**SOIL, GEOLOGY, AND GEOLOGIC HAZARD STUDY  
PARCEL NOS. 43070-00-001 AND 430720-00-015  
WOODMEN ROAD AND HIGHWAY 24  
EL PASO COUNTY, COLORADO**

**Falcon Field, LLC**  
**c/o Springs Engineering, Inc.**  
31 North Tejon Street, Suite 500  
Colorado Springs, Colorado 80903

January 20, 2021

GEOLOGICAL MAP

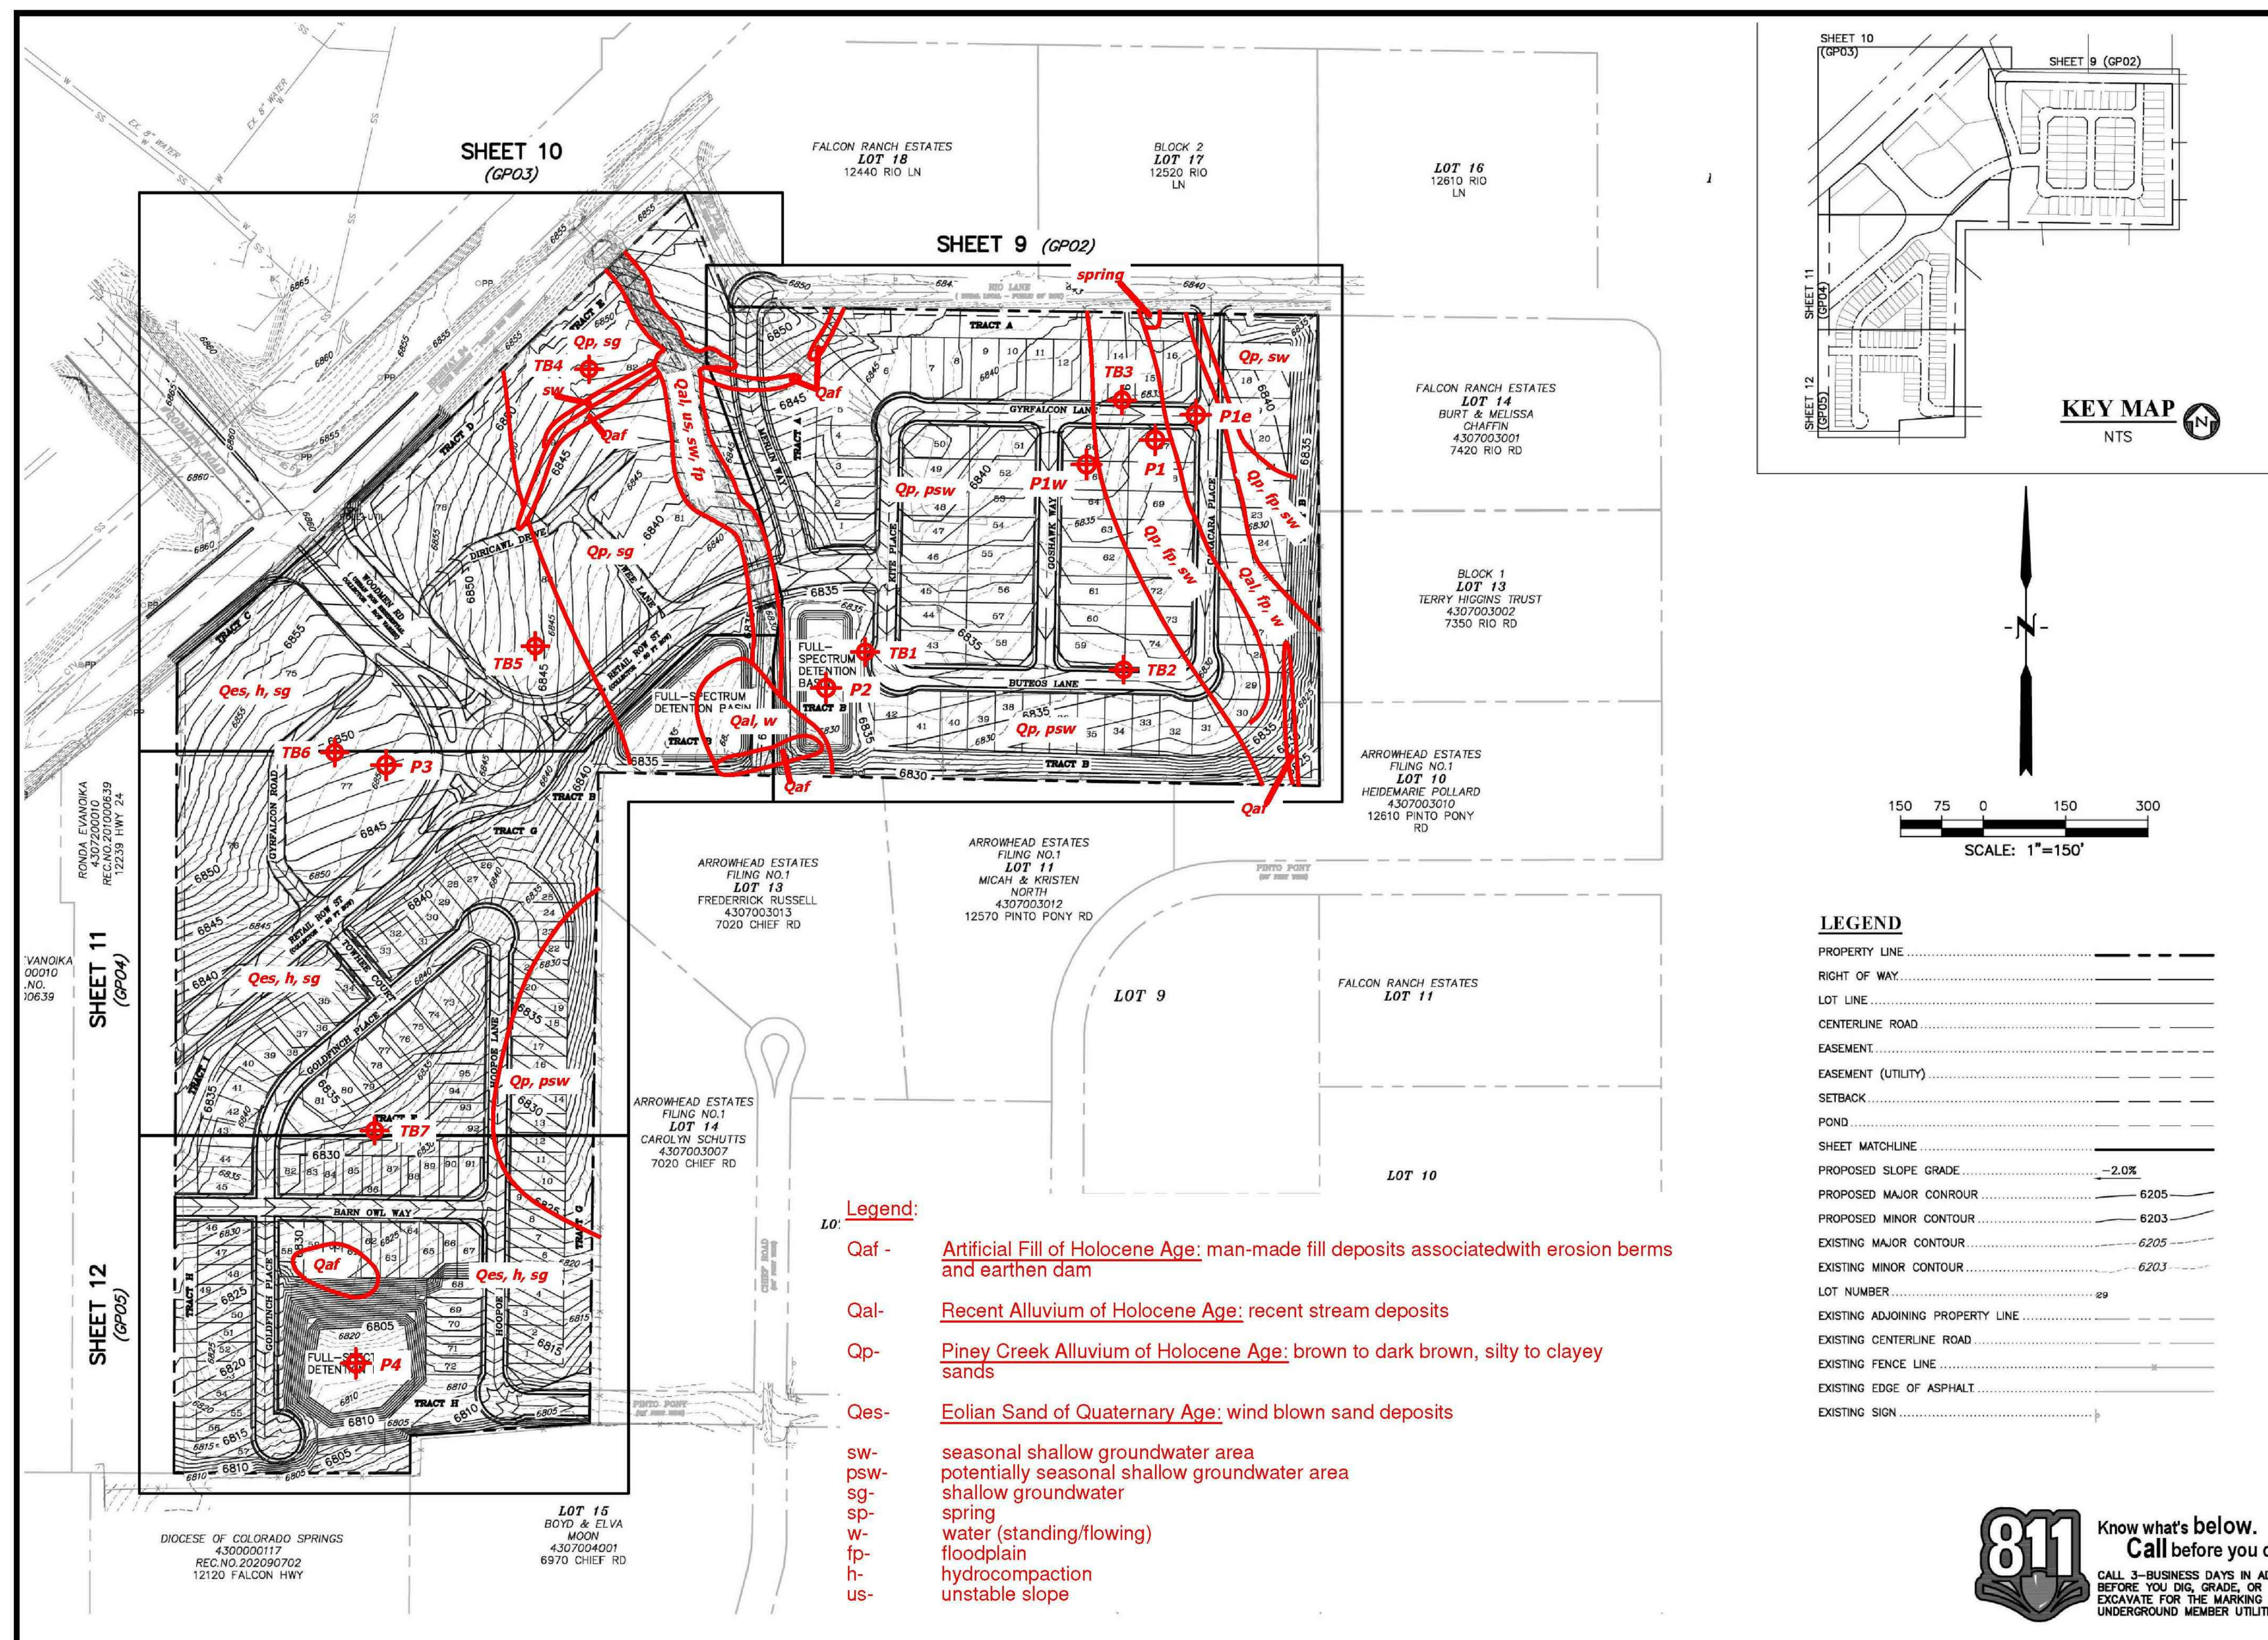
How will shallow groundwater be mitigated for proposed ponds?

What is the long-term solution to bypass spring flows?

Revise map no. to 553G & 561G as shown on figure 7 of your study.
